Development Facilitation Team (DFT) – Review Comments

DRB Project No: PR-2020-003222 Date: 5/24/2023 Agenda Item: NA Zone Atlas Page: B-13

Legal Description: Tract B-4-A Cottonwood Mall

Application For: PS-2023-00024 – Sketch Plat (DFT)

Easement No. 13 Detail

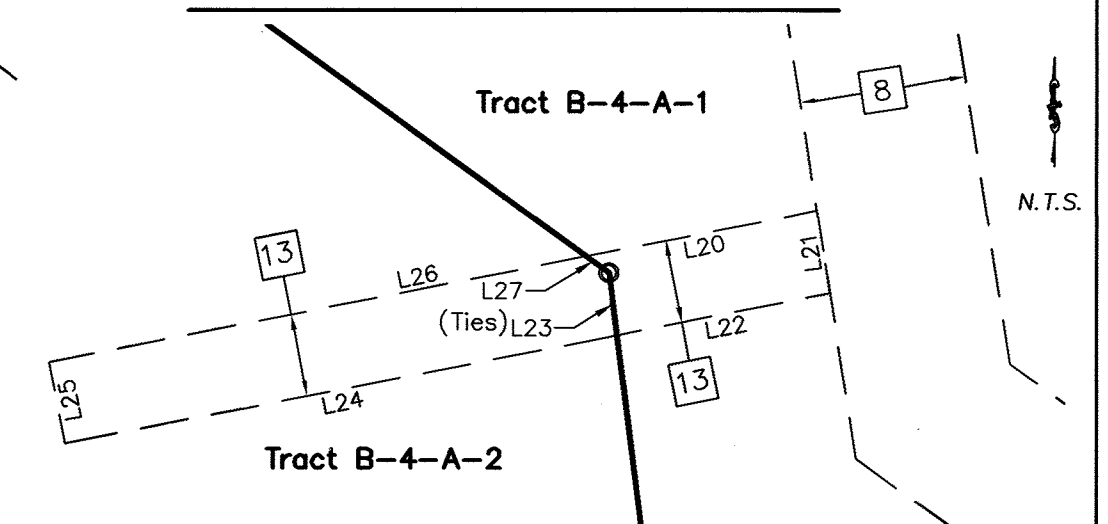
1. There is an existing serviceability letter 230203 and approved service connection agreement executed for the site that provides conditions for service for the site to develop a commercial development on the subject site.
2. No objection to the proposed plat however, please provide a document number for the proposed private sanitary sewer easement or show it as being granted as part of this plat.

The Applicant must clarify how easement # 13 (an existing 20-foot private sanitary sewer easement) is going to serve Tract B-4-A-2; it seems uncertain to Planning staff how the easement is going to serve Tract B-4-A-2. The correct sequencing of the Plats requires that the Plat for PR-2019-003222 / SD-2020-00116 be recorded prior to the approval of this Plat by the DHO.
